DOC ref: DOC19/583156

Your ref: SSD 7187

West Nowra Landfill Expansion – SSD 7187

ROBERTO PUPO
A/Unit Head Waste Compliance
Environment Protection Authority

Figure 8 Sensitive Receptor Locations

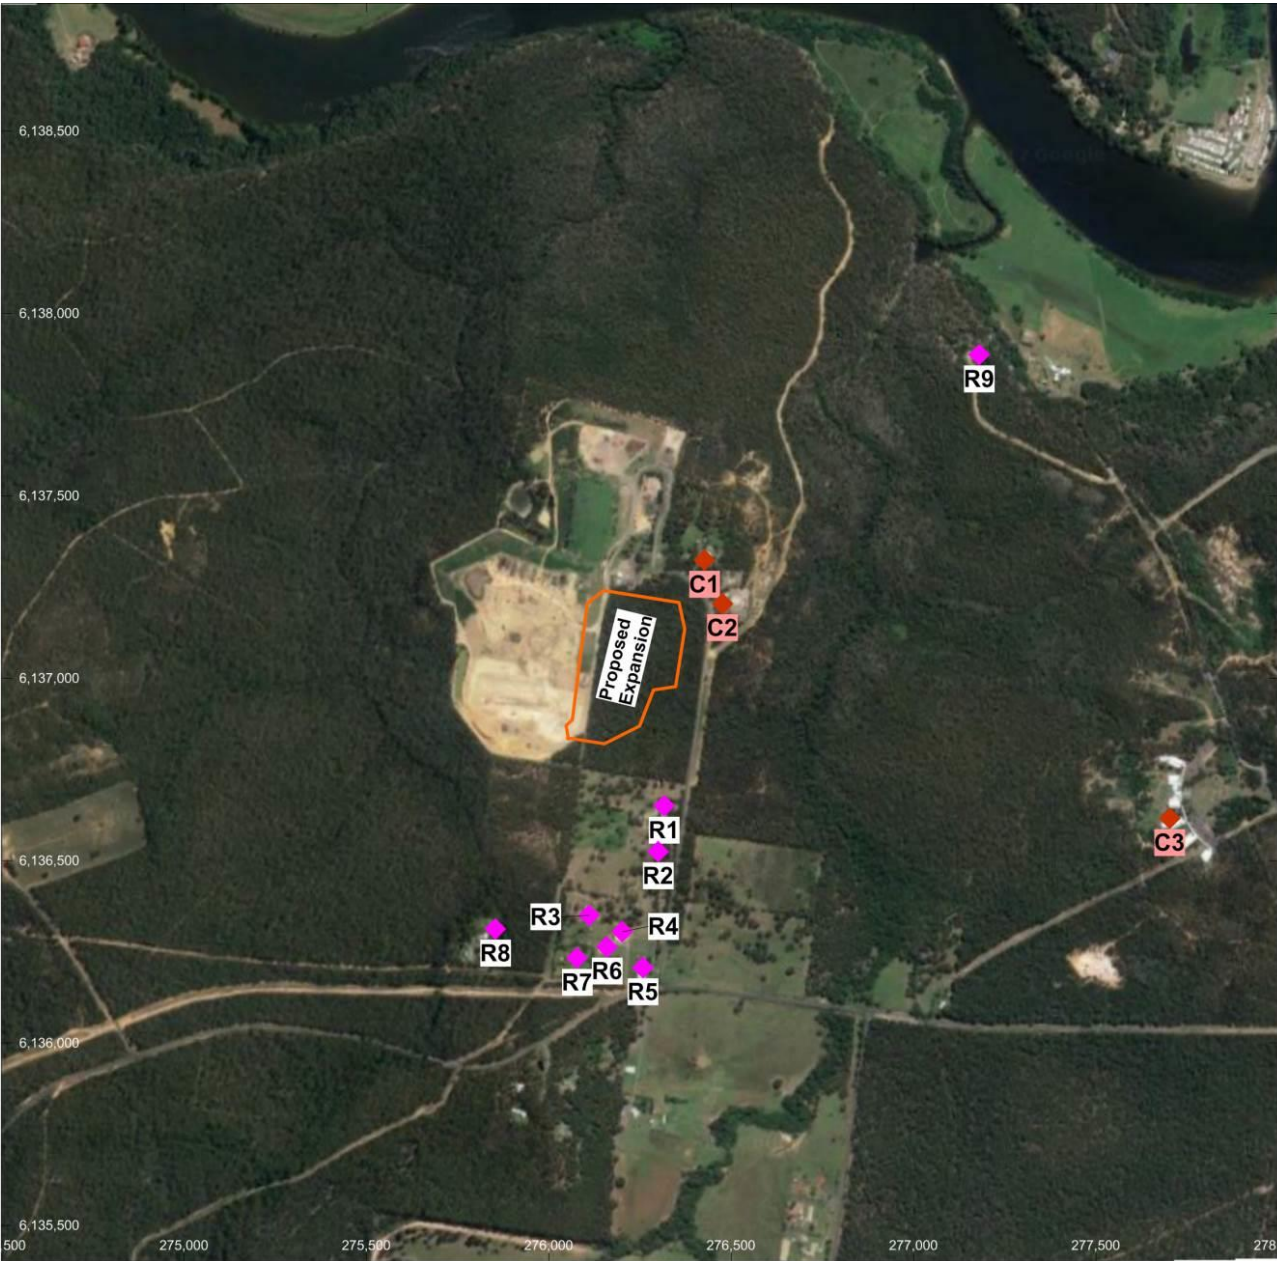
The project derived odour impact assessment criteria has not considered neighbouring commercial receptors

The Air Quality Impact Assessment (AQIA) adopts a project specific odour impact assessment criterion of 5 Odour Units (OU). The project specific odour concentration is based on consideration of nine (9) residential dwellings, and an affected population of 30 people.

The AQIA does not appear to have considered the population of people within neighbouring commercial receptors. The Approved Methods defines a sensitive receptor as "A location where people are likely to work or reside, this may include a dwelling, school hospital, office or public recreational area". As such the assessment should consider the population of people within neighbouring commercial areas.

The EPA recommends the AQIA be revised to include a project specific criterion that is based on the population of people (in all receptors) where ground level concentration of odour equal to or greater than 2 OU are predicted.

Figure 22 Predicted 99th Percentile Nose-Response Odour Concentrations (Includes Leachate Irrigation)

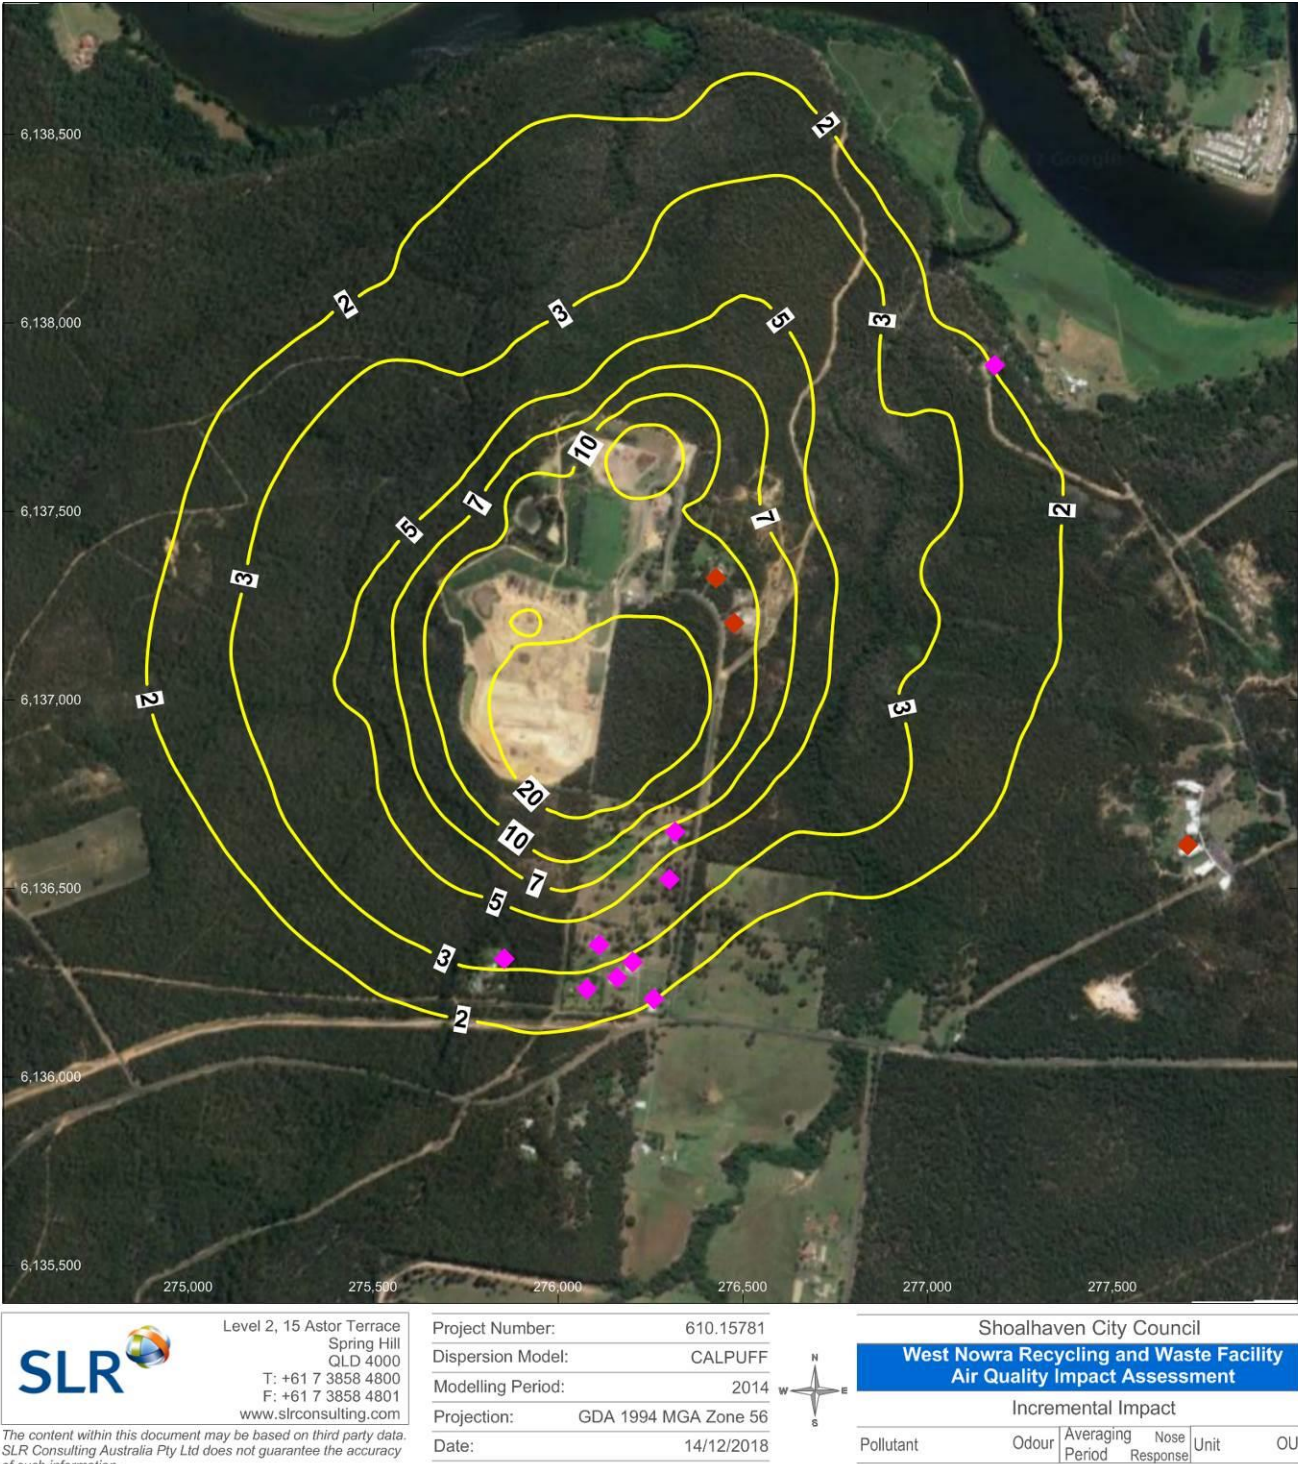
The AQIA predicts exceedances of the adopted odour impact assessment criteria

The AQIA adopts a project specific odour impact assessment criterion of 5 Odour Units (OU). The AQIA predicts:

- A ground level concentration of 6 OU at residential receptor R1. This is above the project specific assessment criteria of 5 OU. Given the close proximity of the new landfill cells to receptors, the predictions are likely to represent an increase in the potential for off-site odour impacts;
- Compliance with the project odour assessment criteria at other residential receptors; and
- Ground level odour concentrations of 13 OU at:
 - Commercial receptor C1 – the RSPCA Shoalhaven shelter. The AQIA advises that this facility has closed, and
 - Commercial receptor C2 – OEH buildings

The EPA notes that sensitive receptors are located within close proximity to the proposal, with some receptors as close as 55 m from the proposed Stage 4 extension. The EPA advises that there is uncertainty with modelling predicted ground level concentrations over such distances, and hence there is uncertainty in the assessment predictions.

The EPA recognises that there is uncertainty with predicting ground level concentrations of odour over short distances. Given that the assessment predicts exceedances at an offsite residential receptor, and that the proximity of new landfill cells to sensitive receptors is likely to represent an increase in potential for offsite odour impact from current operations, then the proponent should investigate options to achieve compliance with the project odour impact assessment criteria, including investigation of options to reduce odour emissions at the source.
